Re: Darlington Terraces Mixed Use Development, University of Sydney (SSD 7539)

Thank you for your correspondence dated 14 May 2018 which invites the City of Sydney ("the City") to review the Environmental Impact Statement ("EIS") provided by the University of Sydney in respect of SDD 7539 and to provide comments on the proposal.

**Figure 4:** Tree 11 in its growing environment. Source Austin 18/06/2014

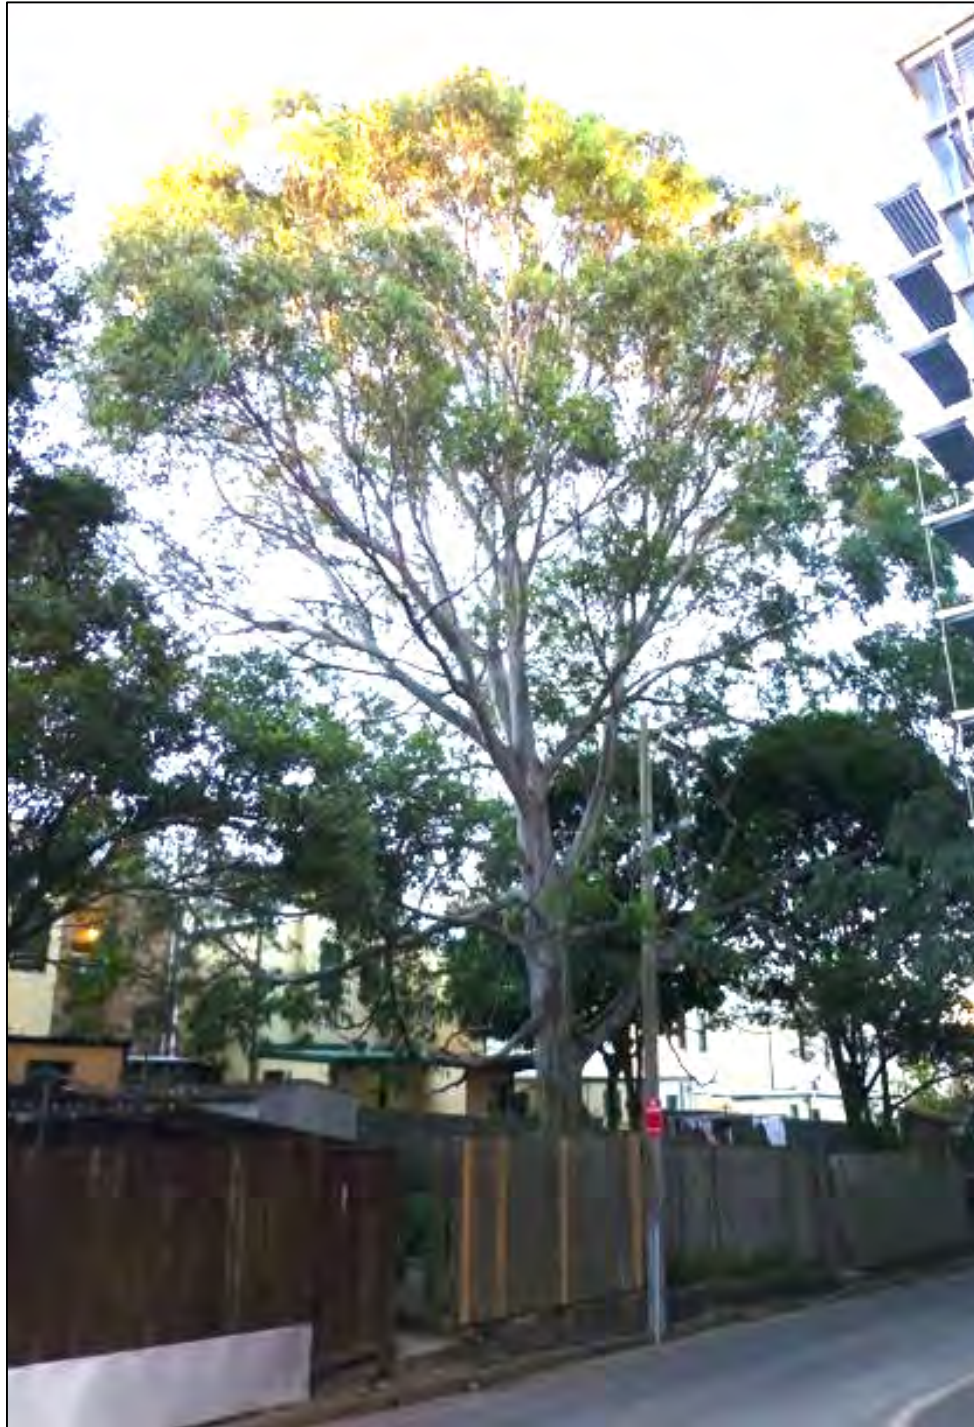
There is a Eucalyptus tree (Tree 11 in AIA) between Buildings B and C, which is identified as having a high retention value and is proposed to be retained with protection zones to meet Australian Standards. However, the proposal disregards those protection zones and creates an encroachment with significant works likely to affect the structural roots of the tree. The current extent of decking (outdoor study area), concrete walls and footings for two disabled access ramps within the TPZ and SRZ of the tree need to be revised to ensure the longevity of the tree.
